Project: 116 Lthica lane
Location: Bunnlevel, NC
Date: 10/26/23
Company: _____
Care Of: Shawn Spears
(919) 669-9462

As requested, A. Takla (Engineer of record) prepared this report to address the following items: -

FOUNDATION AND FLOOR FRAMING PLAN 1/4" = 1'-0"

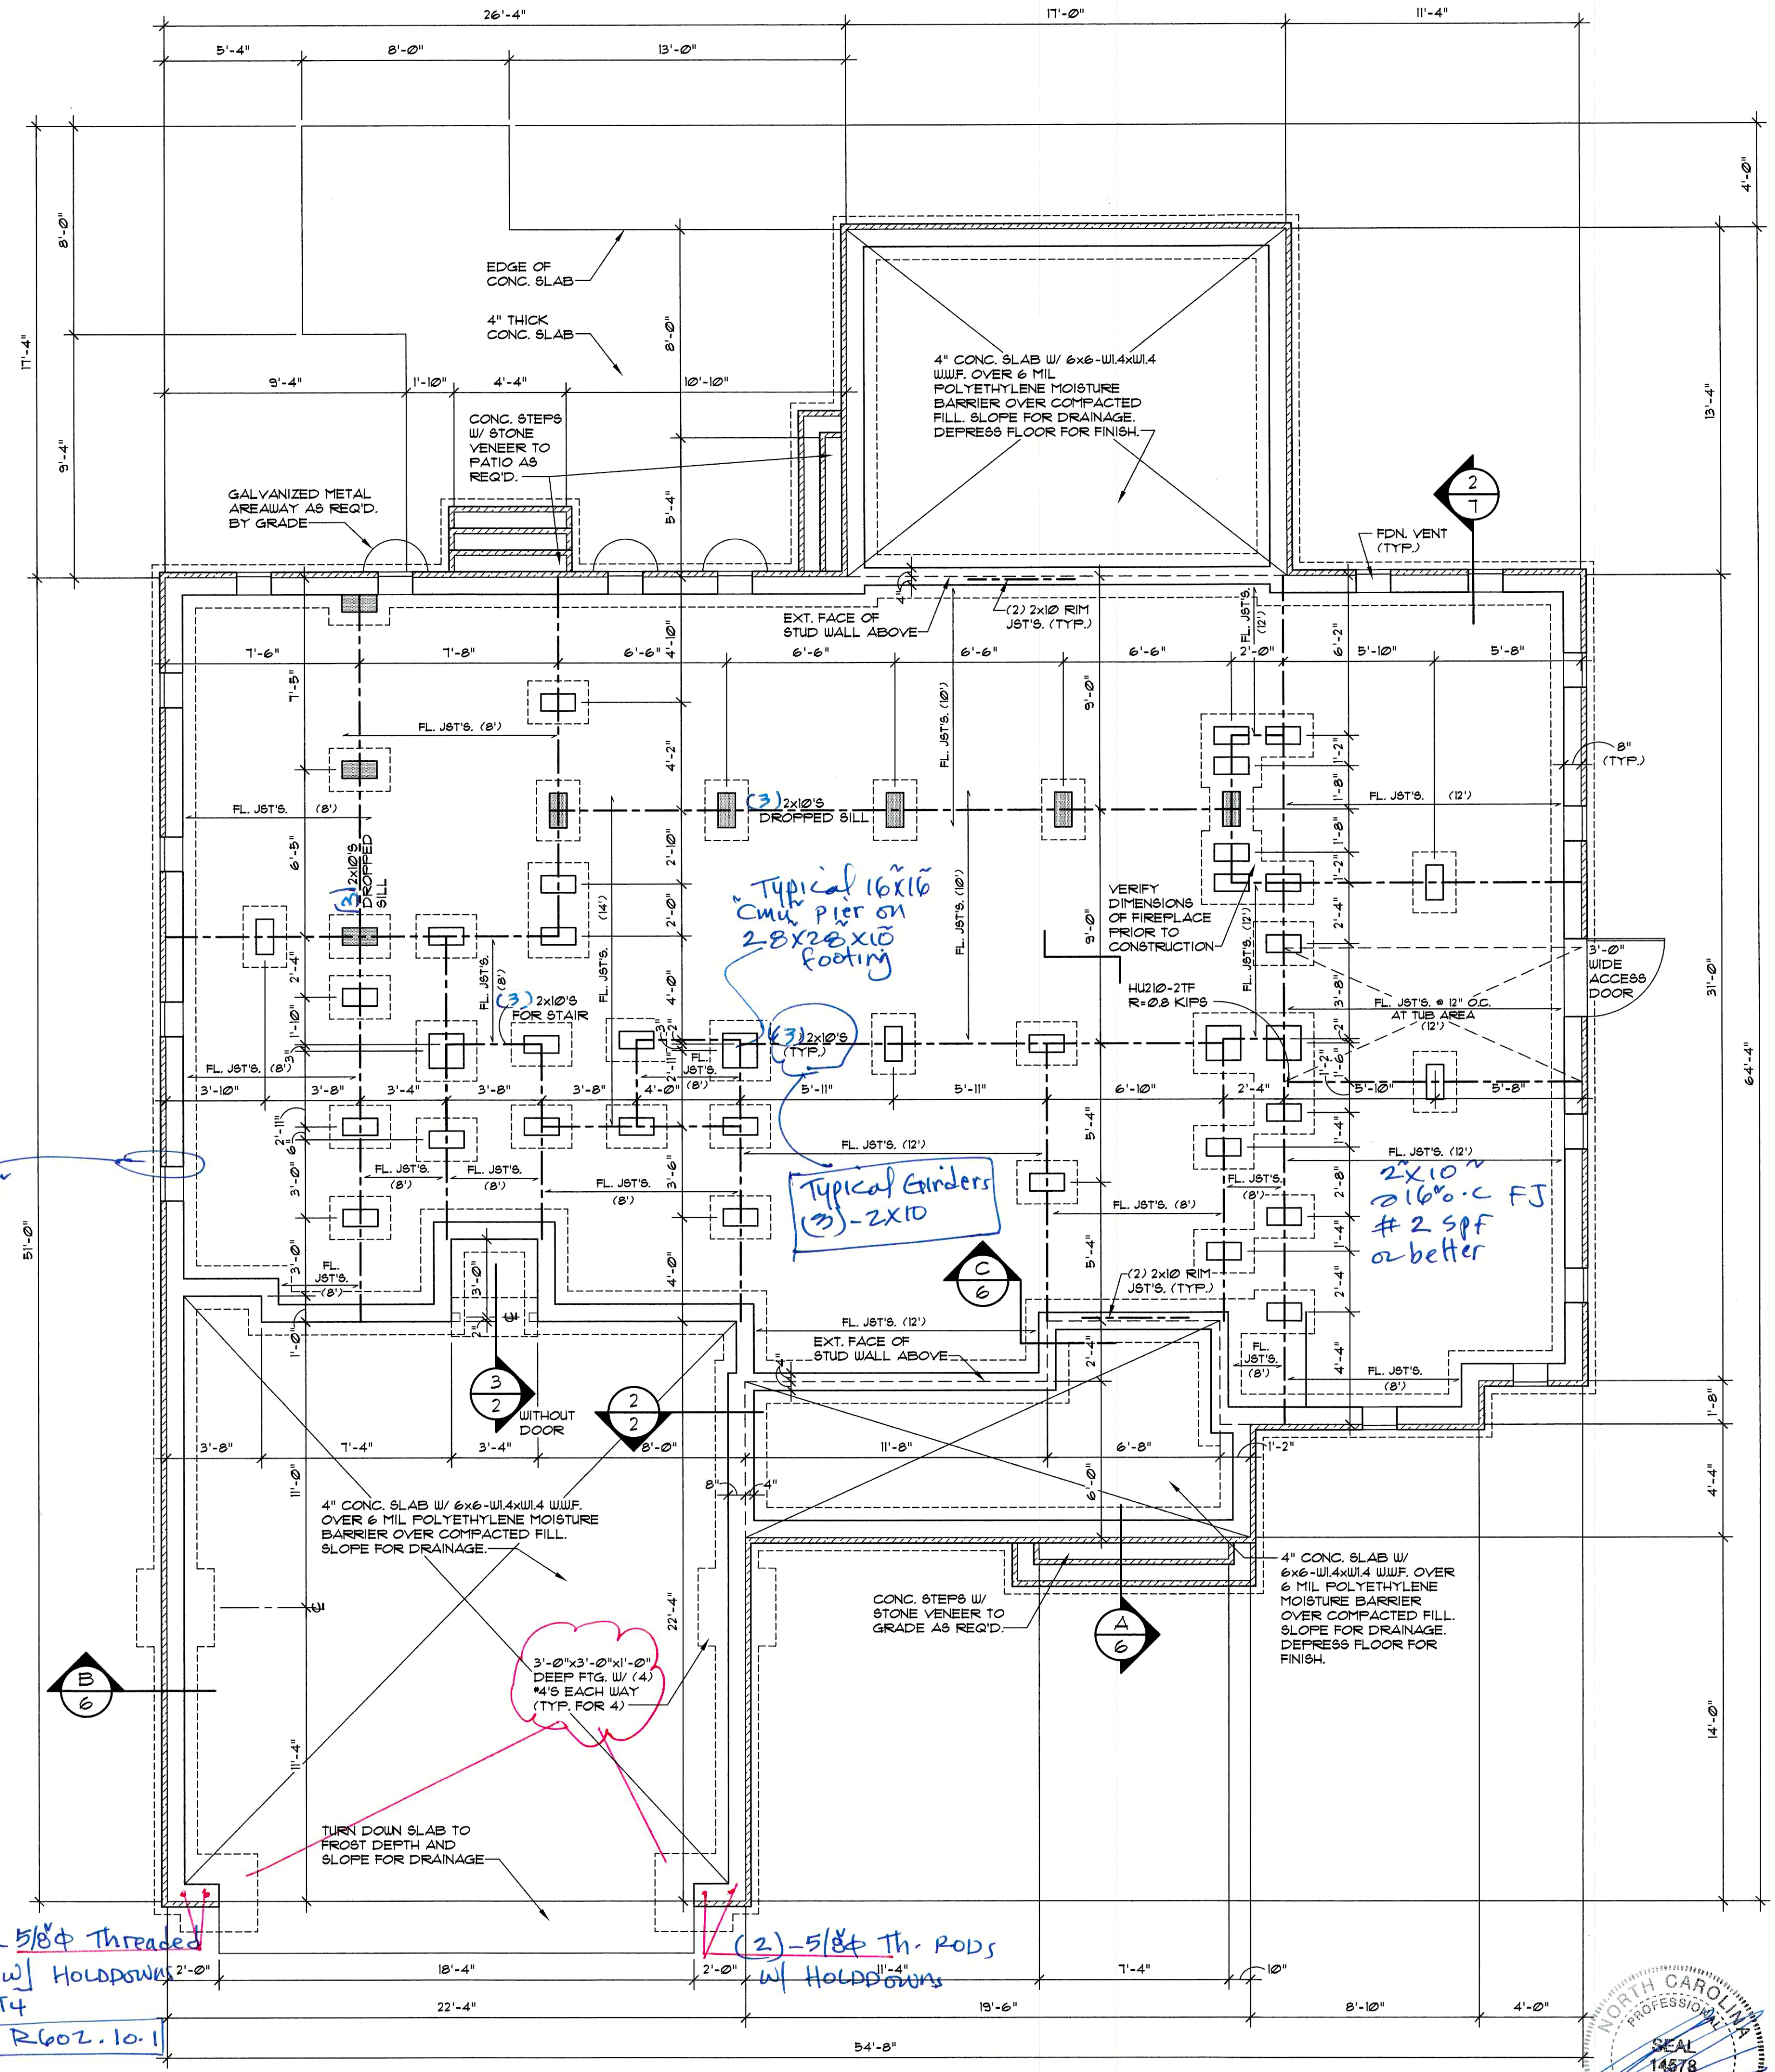
- (A) Add 2x10 stud to existing LVL beam column nailed w/ (3) -10d nails to B.O.C Flat against the existing 2x4 studs @ the Garage.
- (B) Hand written notes on the plan are done by A. Takla P.E.
- (C) missing 2x10 joist under the closets doors wall is not needed.
